# Appeal Decision

**Appeal Ref: APP/T2350/W/16/3154040**

**3 Accrington Road, Whalley, BB7 9TD**

- The appeal is made under section 78 of the Town and Country Planning Act 1990 against a refusal to grant planning permission.
  - The appeal is made by Mr Peter Street against the decision of Ribble Valley Borough Council.
  - The application Ref 3/2016/0387, dated 21 April 2016, was refused by notice dated 20 June 2016.
  - The development proposed is the demolition of stone boundary wall and creation of a 2-storey extension to accommodate ground floor retail space and a first floor one bedroom flat.
-

PROPOSED SECTION AA

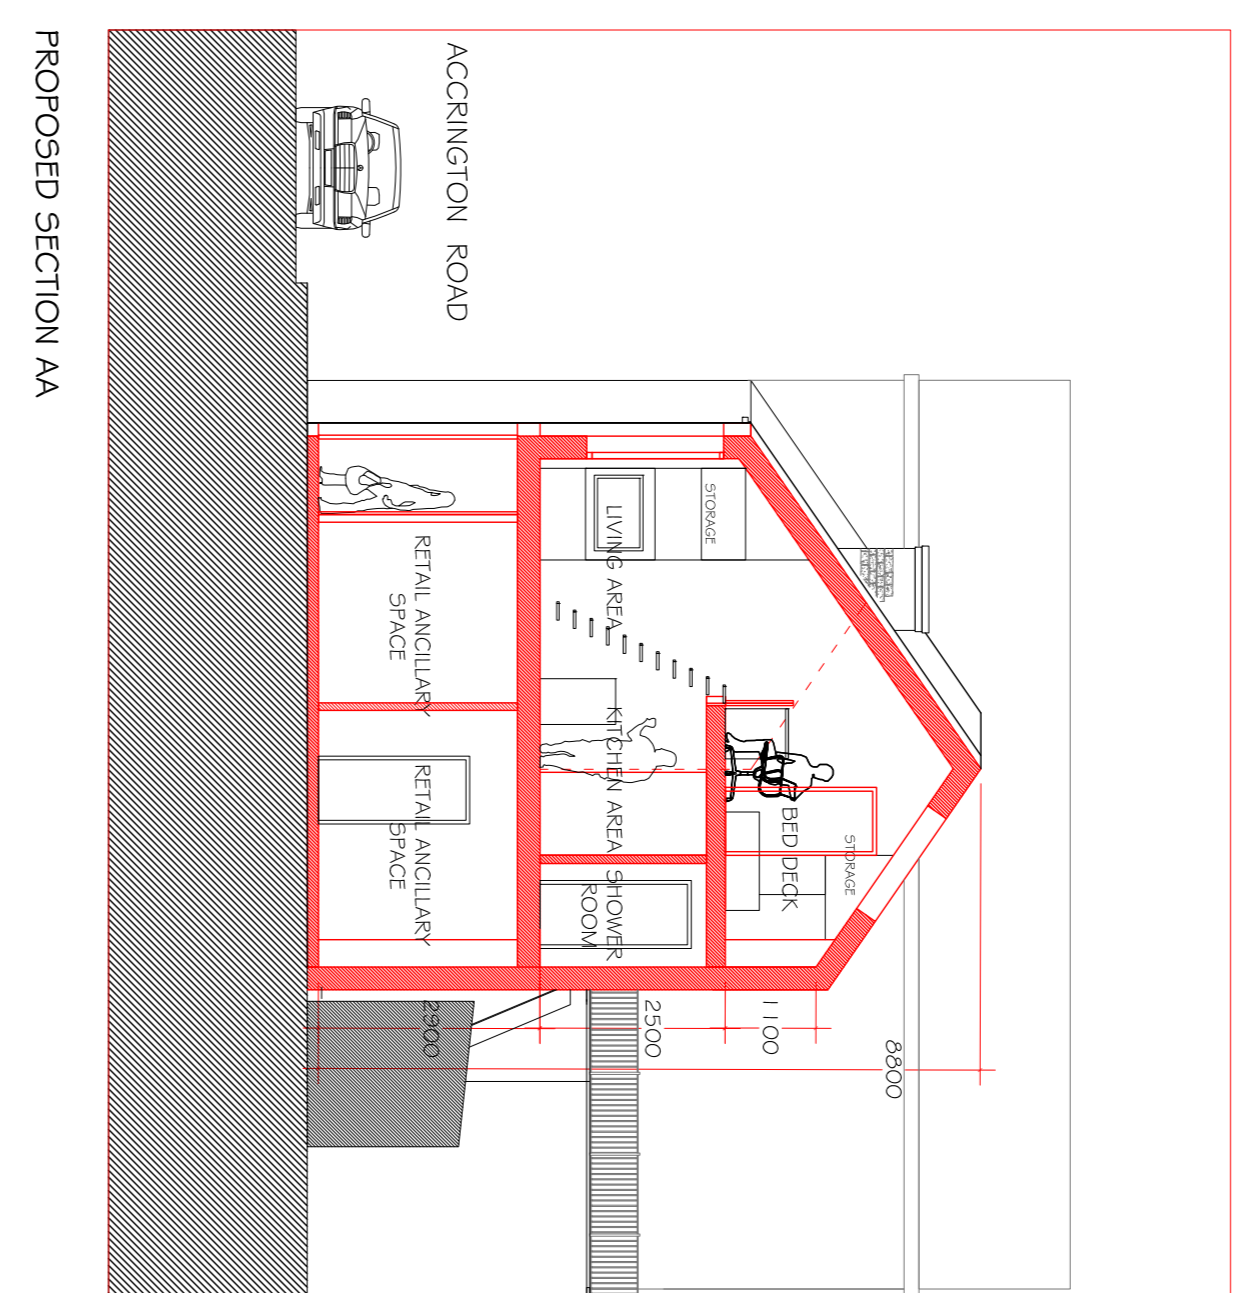
4. The proposed structure would have two full storeys and a tall roof which would accommodate a bed deck. Whilst the eaves at the front of the proposed building would align with those of No 3, the eaves at the rear would be higher and the pitches of the front and rear roof-slopes would not match each other. As a result the ridge of the roof would be substantially taller than that of the adjoining building. The mis-match between the new and existing eaves, roof heights and roof pitches would result in an unattractive and incongruous addition to the BTM.

PROPOSED FRONT ELEVATION

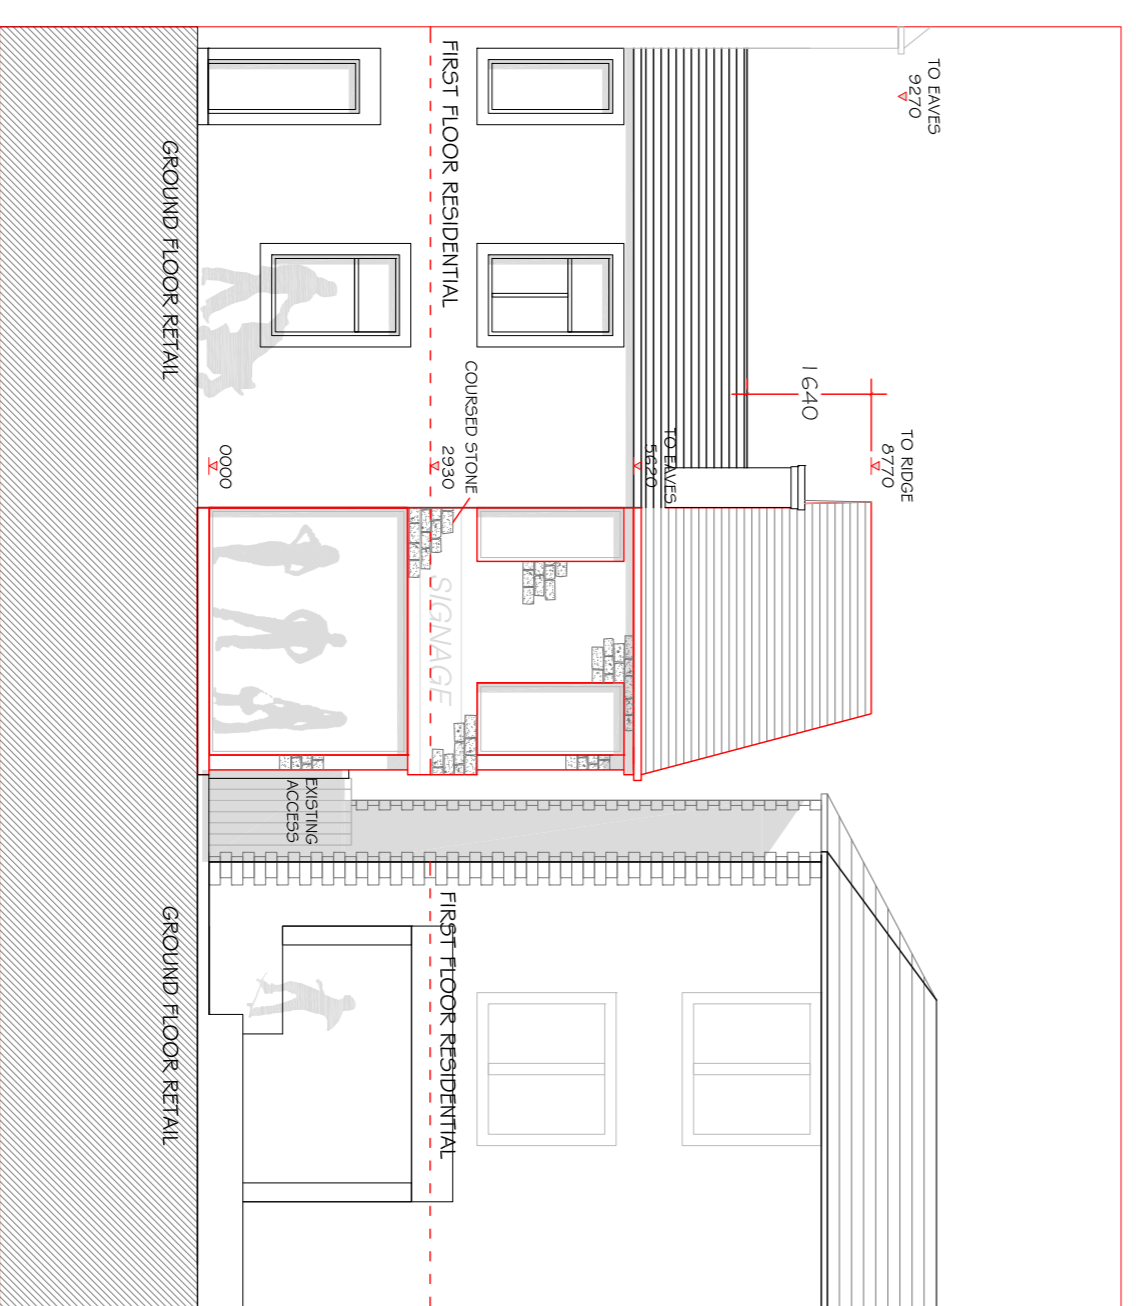
- next door is an example of such a format. Conversely, the proposed shopfront would be a large window which would wrap around the corner of the building giving the impression of the 1<sup>st</sup> floor floating above it. This design would be at odds with surrounding traditional shopfronts.

6. In addition, whilst the upper floor windows would line up with the other windows in Nos 1-3, they would lack glazing bars and the window wrapping around the corner would further exacerbate the “light-weight” appearance of the front façade. The generous use of glazing would be inharmonious amongst the surrounding solid and traditionally proportioned buildings. In summary, the proposed building would introduce a style that would be visually incompatible with, and would dilute, the character and appearance of the conservation area.
